Portishead Branch Line (MetroWest Phase 1)

8.14, Addendum to the Master Construction Environmental Management Plan The Infrastructure Planning (Applications: Prescribed Forms and Procedure)

Version	Date	Status of Version	
01	20/9/2021	Matters relating to the removal of Trinity Primary School pedestrian and cycle bridge

Drawing
**PORTSHHEAD STATION CAR PARK
LAYOUT, LANDSCAPING AND NEW
BOULEVARD AND ACCESS PLAN
SHEET 1 OF 3**

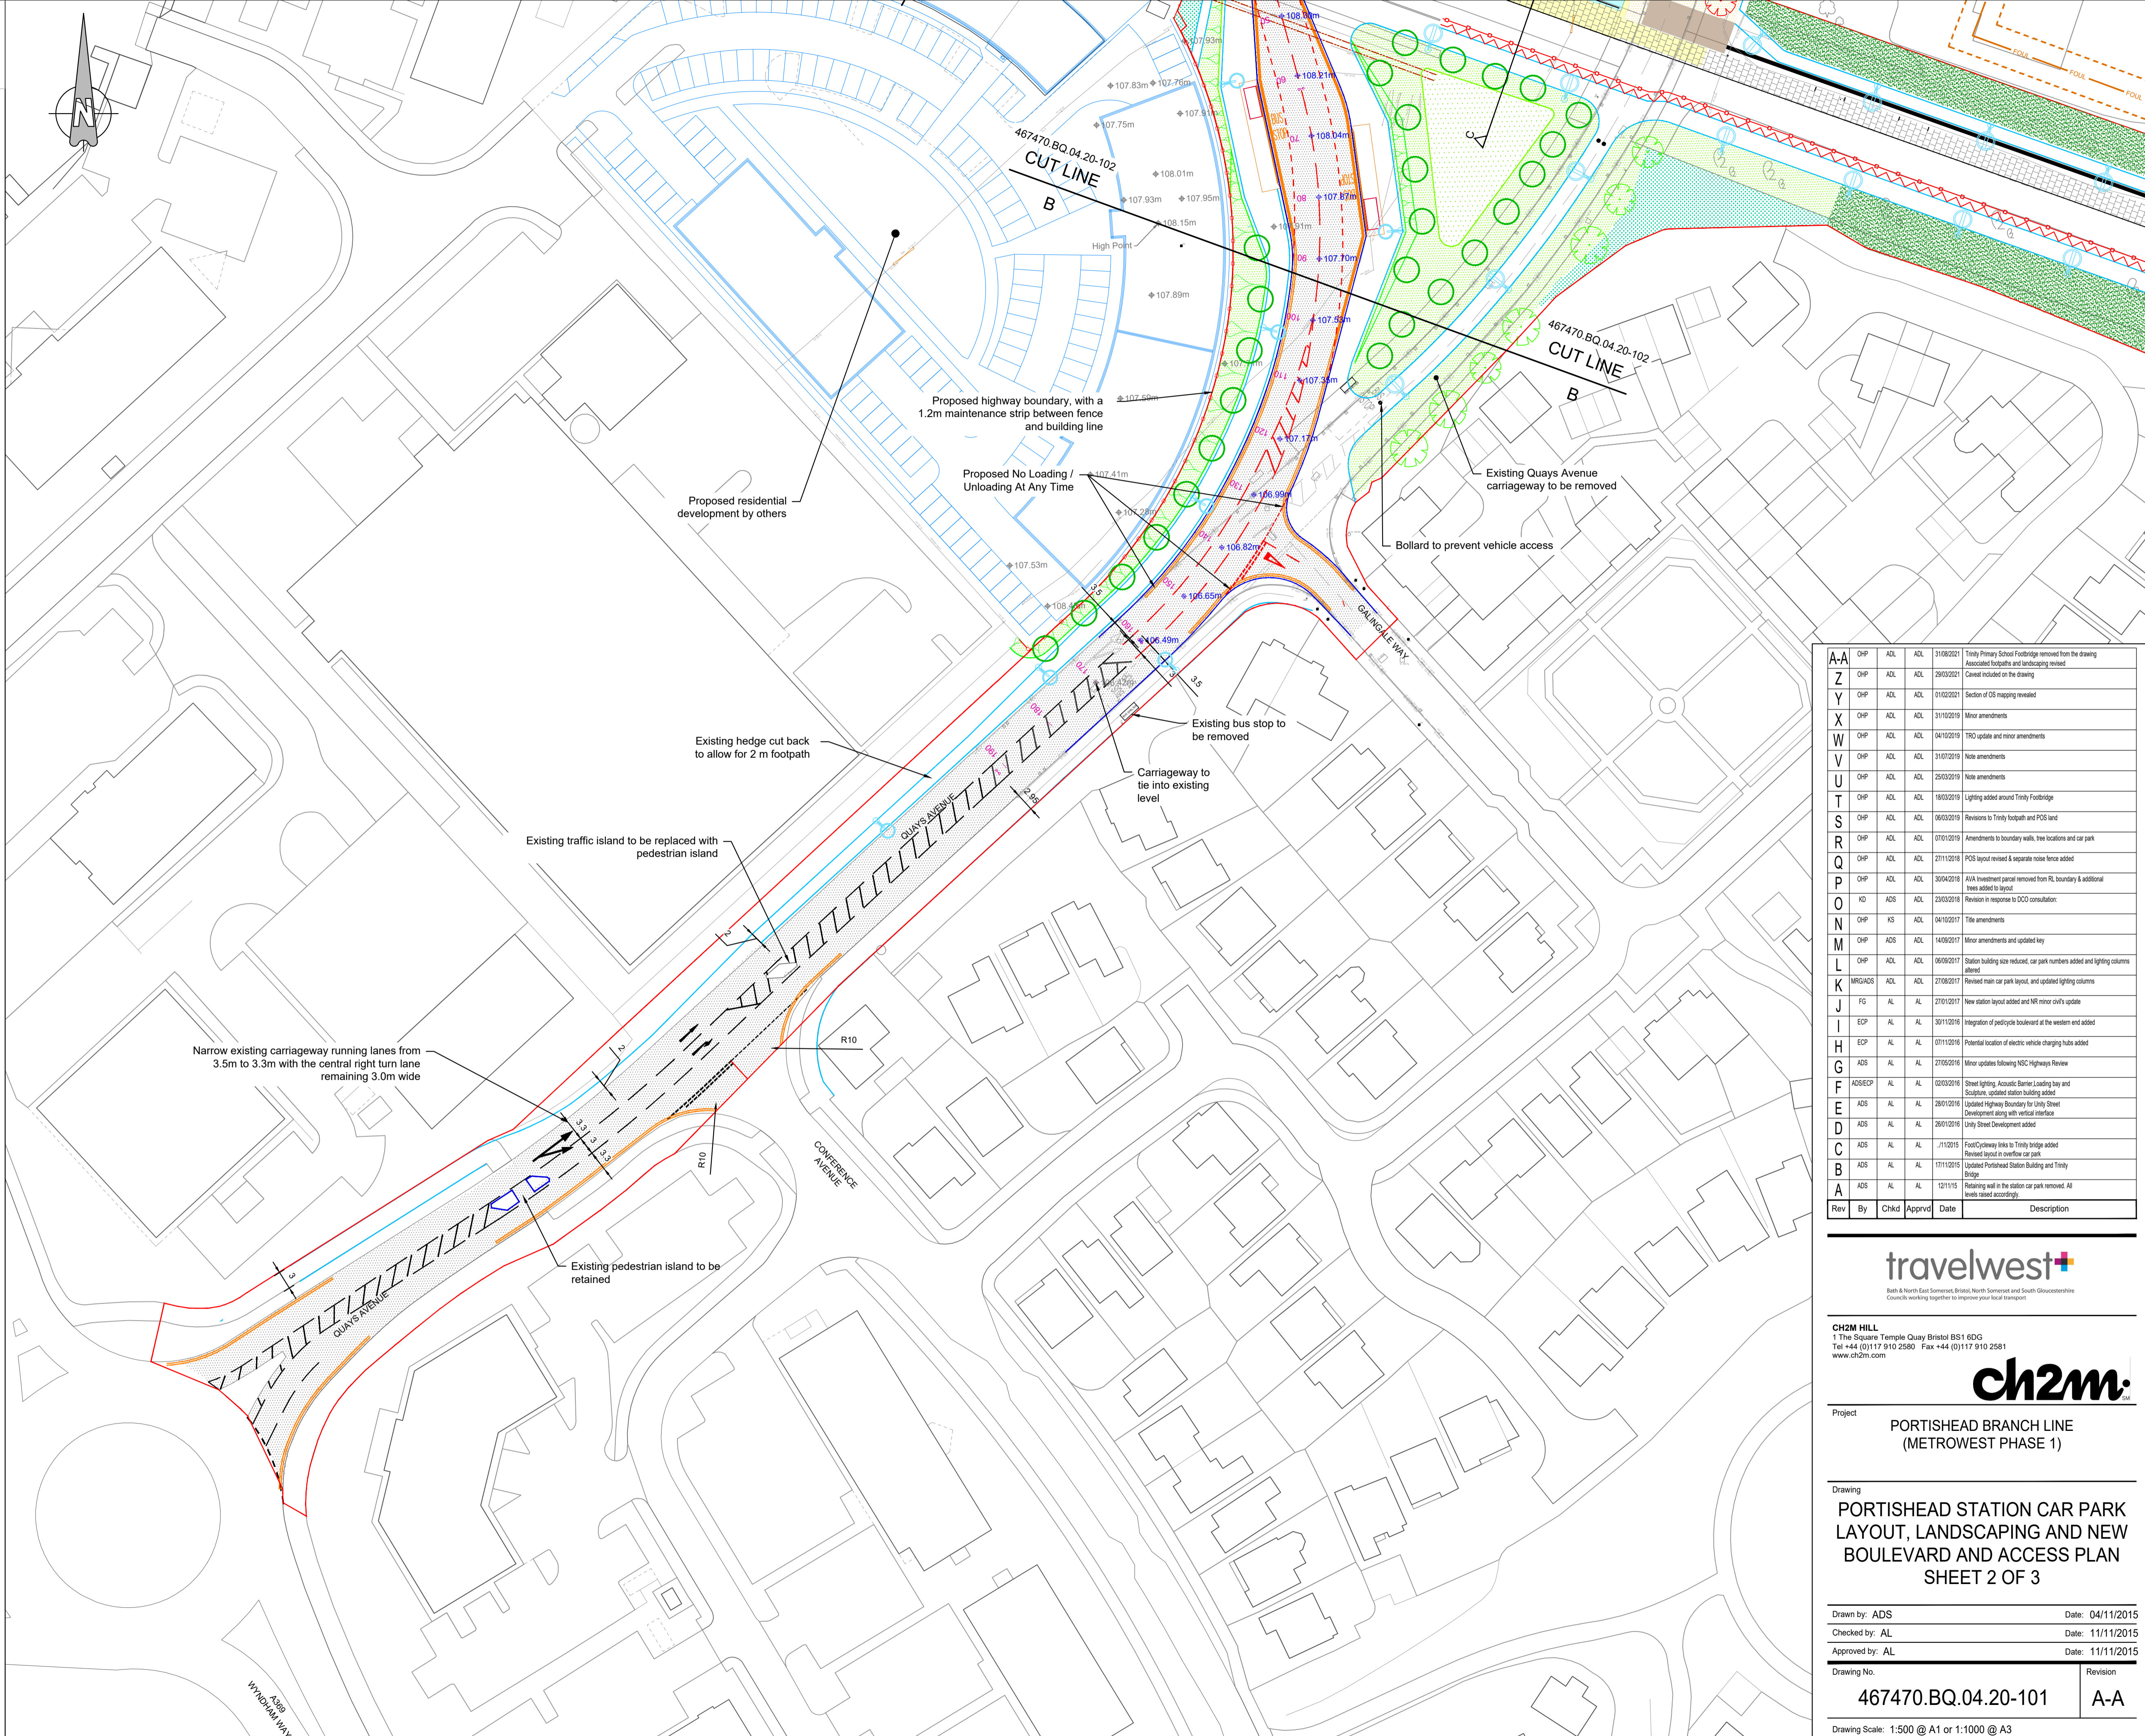
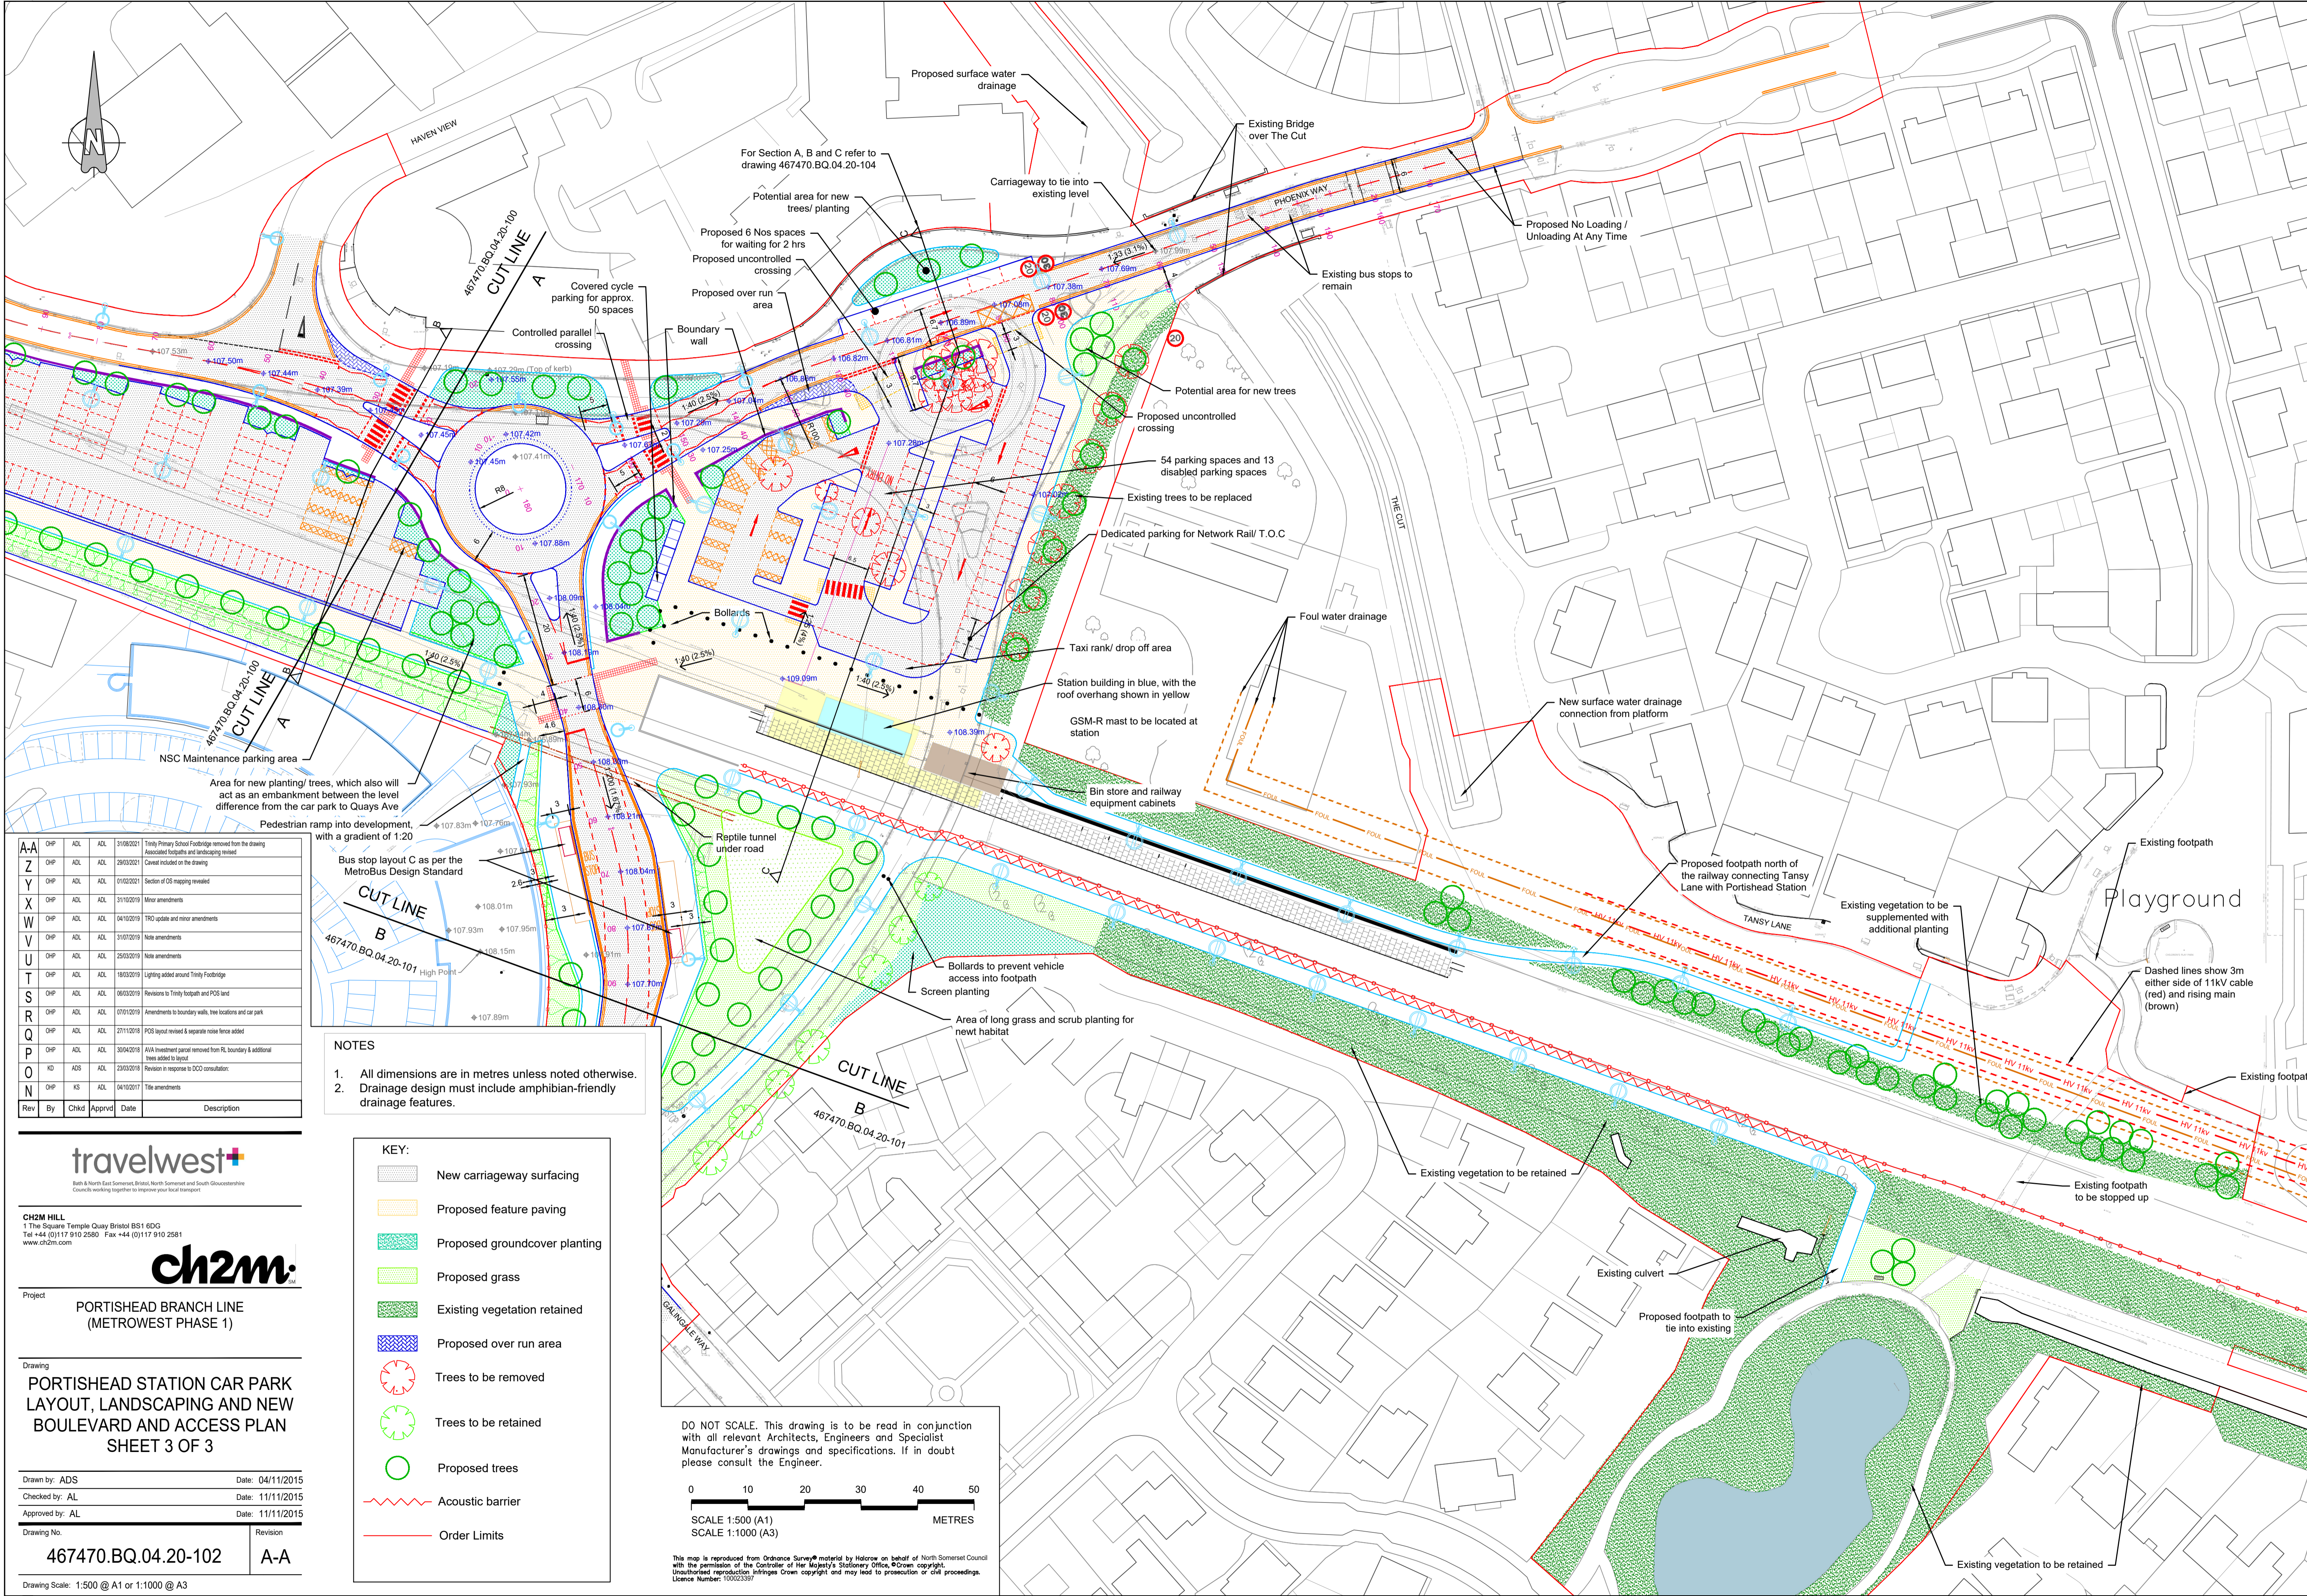
2.1.1 Table 3.1 Summary of current and proposed construction compounds is modified to remove reference to Trinity Primary School Bridge.

Place Name	Location	Land Use	Proposed Principal Construction Use Subject to Detailed CEMP
Portishead Station Site Compound	Portishead on site of new station car parks A and B	Urban highways, railway corridor	To facilitate construction of new station and Trinity Primary School Bridge.
Tansy Lane; Portishead	Trinity Primary School Bridge Lay Down Area	Open space	Storage of materials and assembly for Trinity Primary School Bridge.
